PLANNING CONSULTATION RESPONSE

Application No	2026/0606
Proposal	Reserved Matters application (with layout, scale, landscaping and appearance under consideration) for the erection of 173 dwellings, laying out of open space and associated infrastructure pursuant to outline planning consent 2024/0122 (Appeal APP/R4408/W/25/335991): Outline planning application for demolition of existing structures and erection of residential dwellings with associated infrastructure and open space. All matters reserved apart from access into the site
Address	Land north of Hemingfield Road, Hemingfield, Barnsley
Date of Consultation Reply	
Consultee	Strategic Housing

APT GF M4(3), APT FF (OP-OP) PLANS & ELEVATIONS

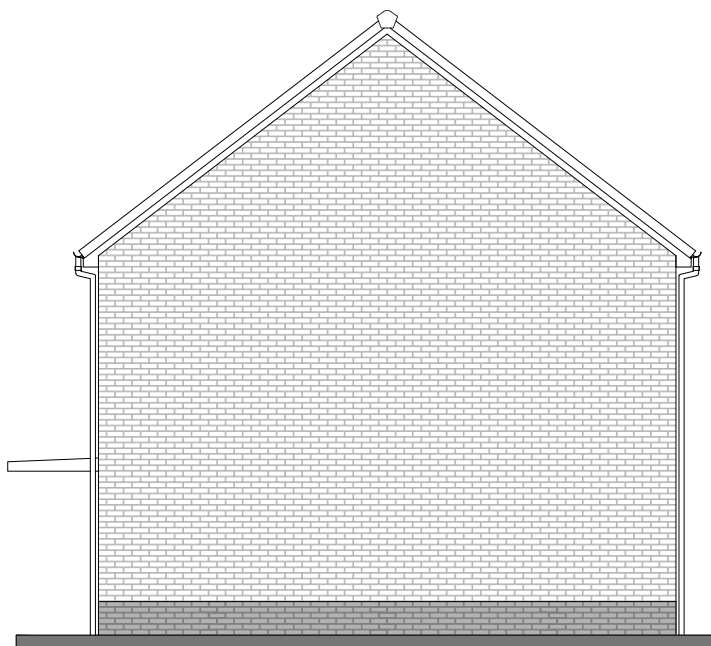
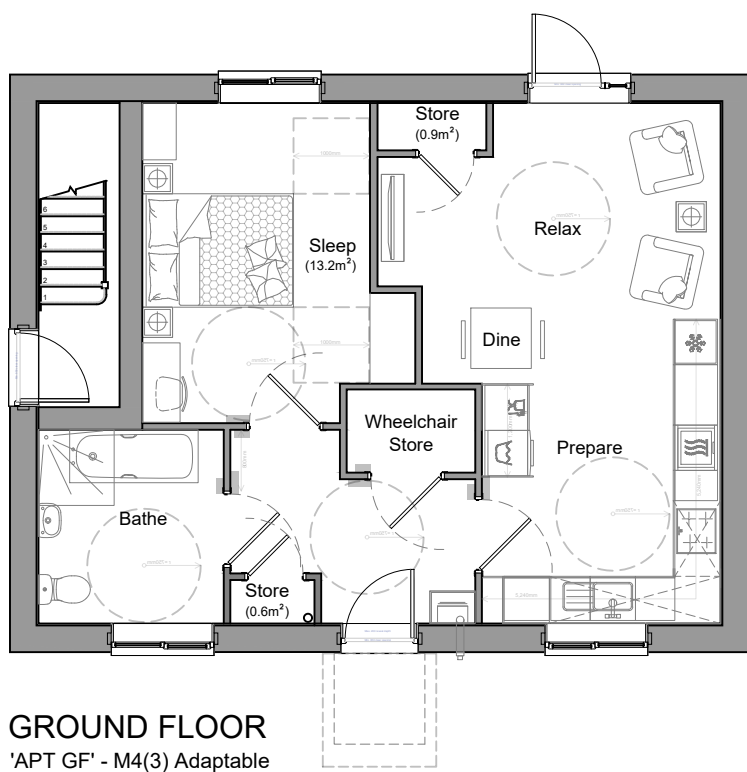
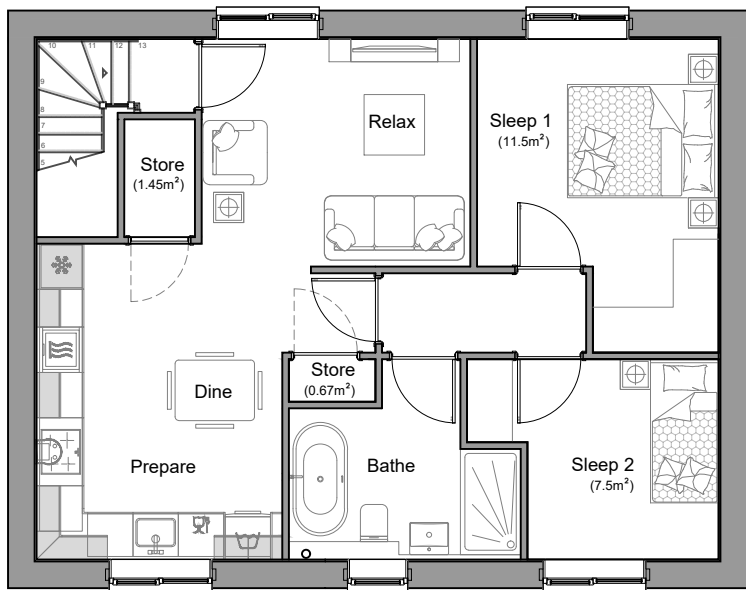
The applicants Affordable Housing Statement (point 3.9 shown below) suggests that all 17 affordable homes are accessible. However, there are 4 first floor flats in the affordable provision with stair access.

The layout plan shows 10 plots marked as M4(3) - the ground floor flats and 3 bed houses. None are marked on the plan as M4(2)

The applicant should review their figures and amend the statement or layout plan as needed.
